Arun District Council
Arun Civic Centre
Maltravers Road
Littlehampton
West Sussex BN17 5LF
Planning & Building Control General Enquiries
Tel: (01903) 737756 Fax: (01903) 730442
Dx: 57406 Littlehampton
Minicom: 01903 732765
e-mail: planning@arun.gov.uk
website: www.arun.gov.uk/planning

Application No: BN/153/20/PL
Site Address: Warwick Nursery Barnham Road Eastergate Barnham PO203RT
Description of works: 44 No. dwellings & associated infrastructure. This site falls within the BEW Strategic Site, CIL Zone 1 (Zero Rated).

Thank you for your internet representation made on 10th February 2021 which has been recorded as an objection with the comments as follows:

Access Drawing / Traffic Calming Measures / Visibility Splays

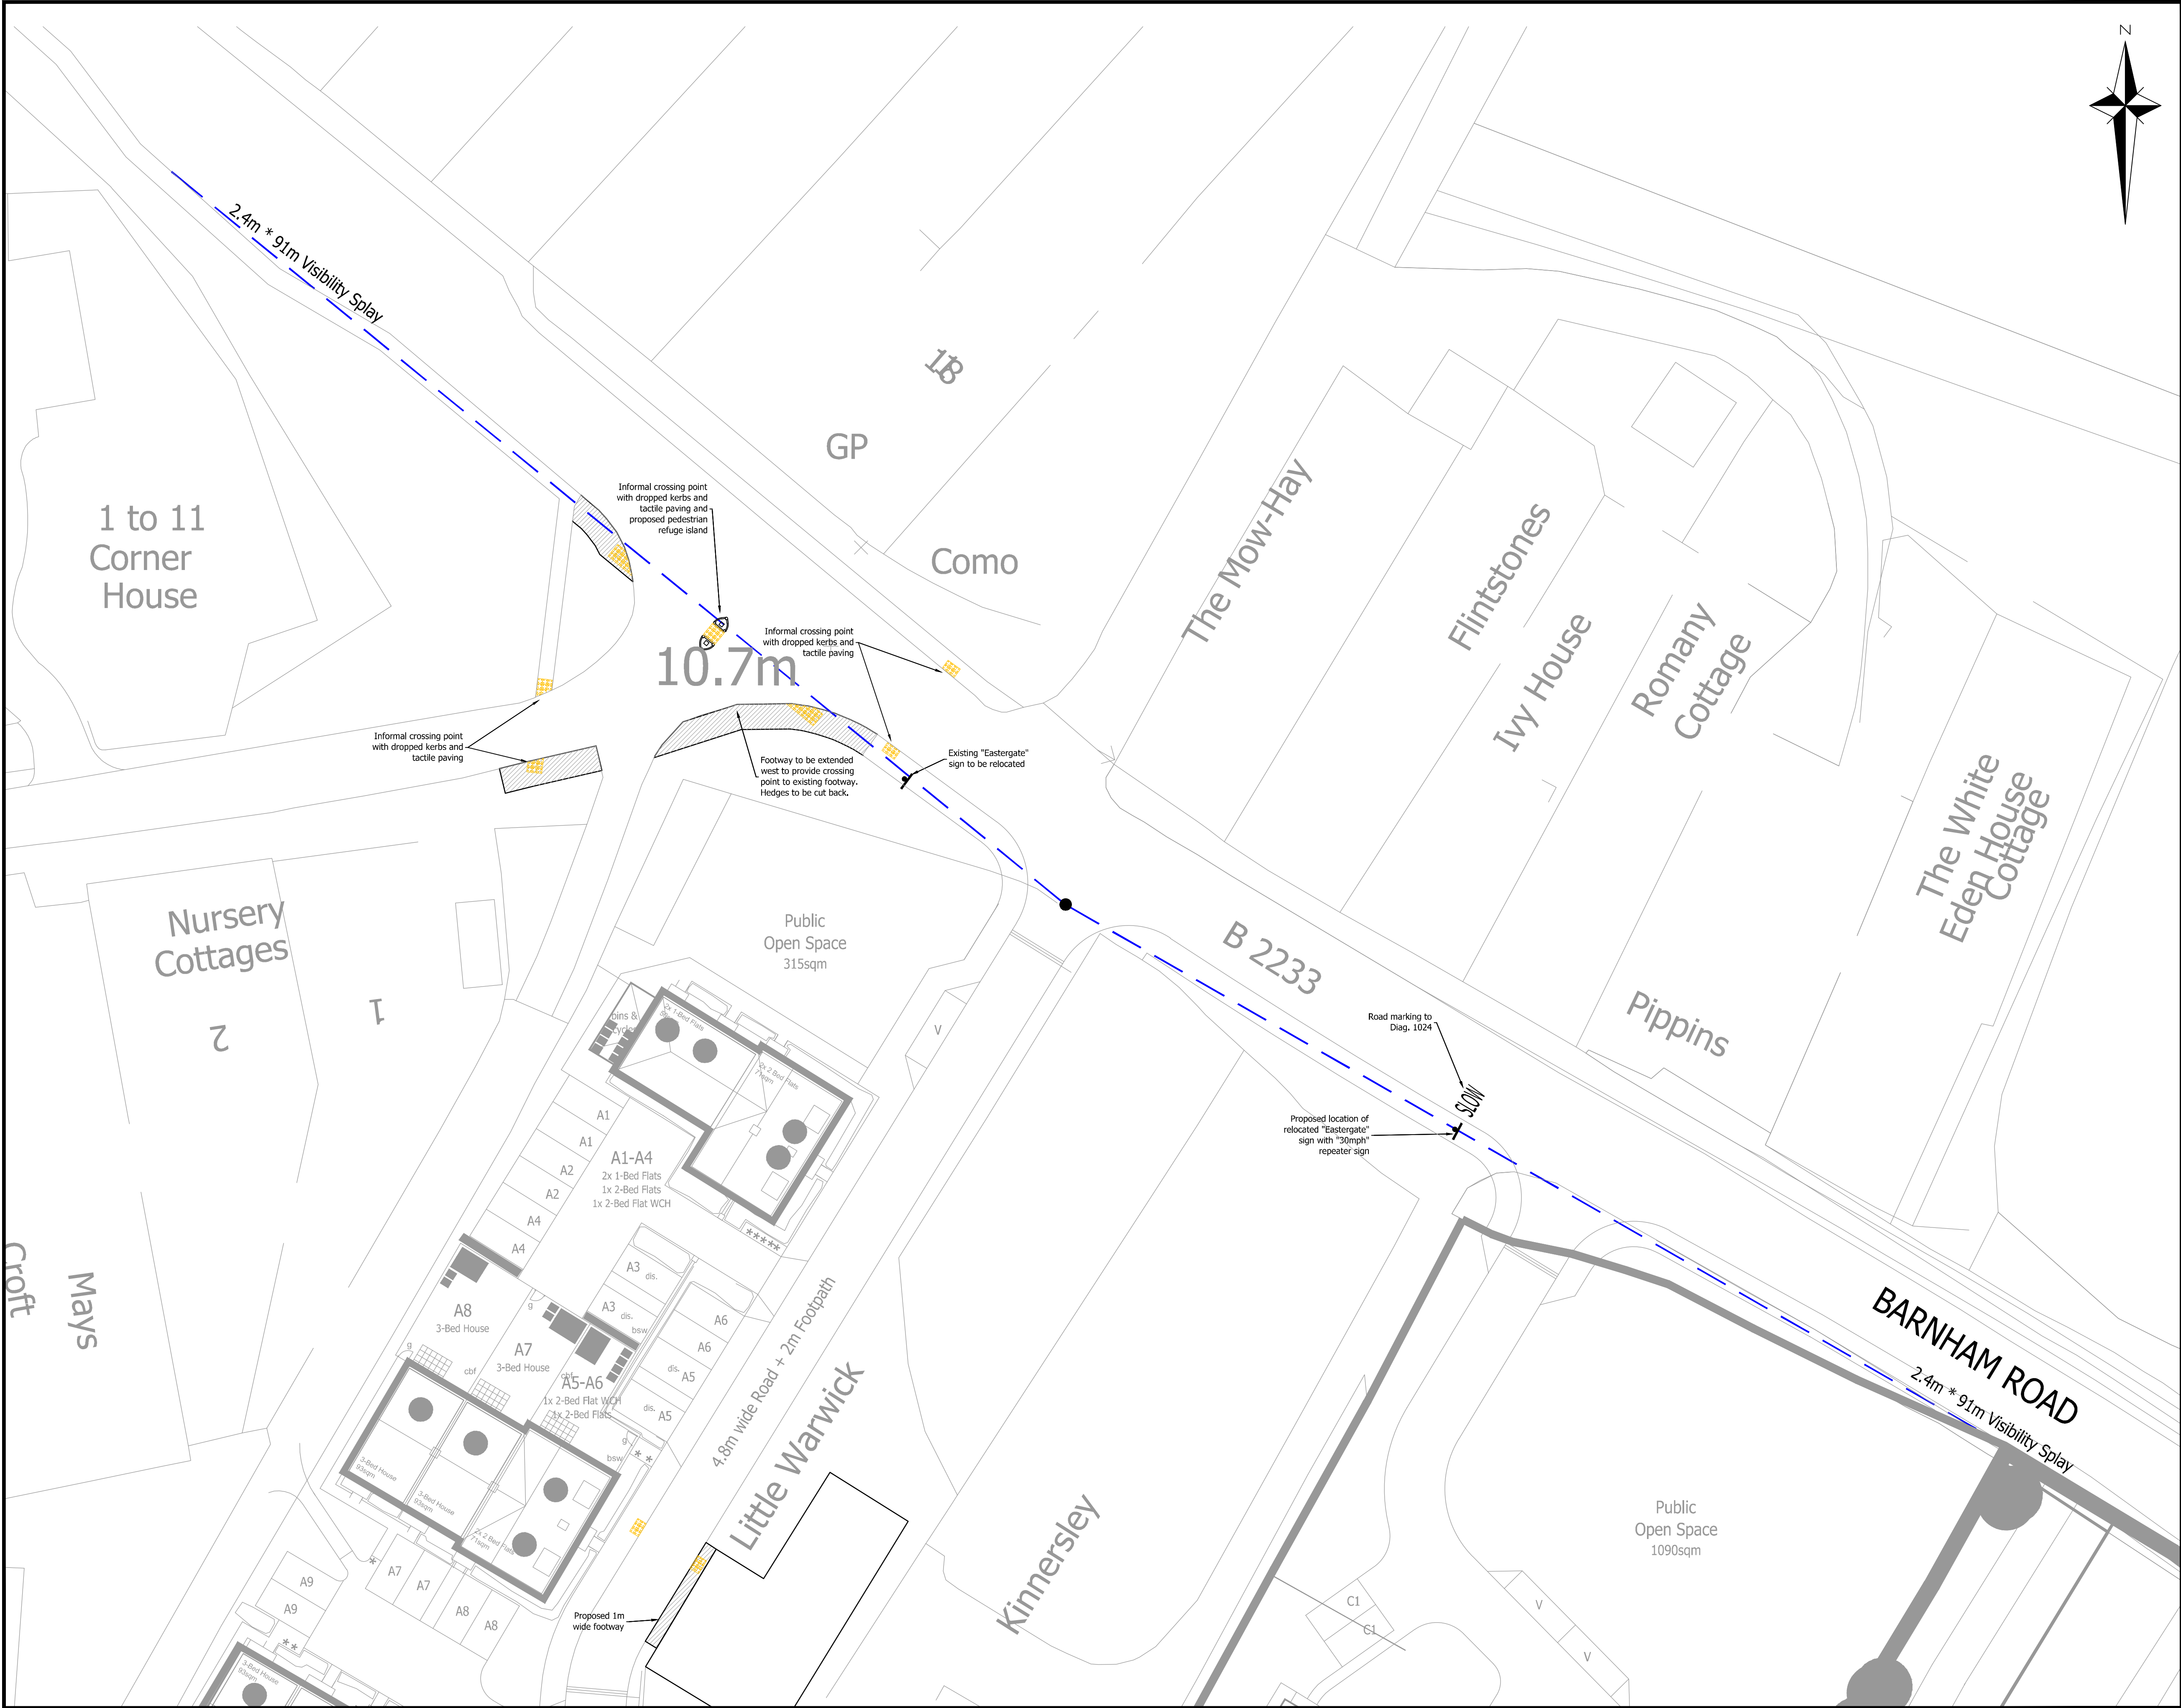
Dangerous repositioning of Eastergate sign, easterly visibility splay to B2233 (appendix C page 44): The planned relocation of the Eastergate village sign will make egress from Kinnersley unacceptably dangerous. Highways England Response 3/2/21 agrees the re-positioning of the sign needs to be addressed. The proposed relocation will obstruct Kinnersley B2233 view to the west, block the view of vehicles leaving Warwick Nurseries development and of vehicles leaving Church Lane. Also it will prevent vehicles travelling east along B2233 from seeing vehicles attempting to leave Kinnersley. The redesign needs to be based on the actual Kinnersley access, not the speculative BEW mini masterplan.

Kinnersley tree protection: the root ball of Kinnersley mature trees on the northern boundary need to be protected during and post construction of the easterly splay to the B2233.
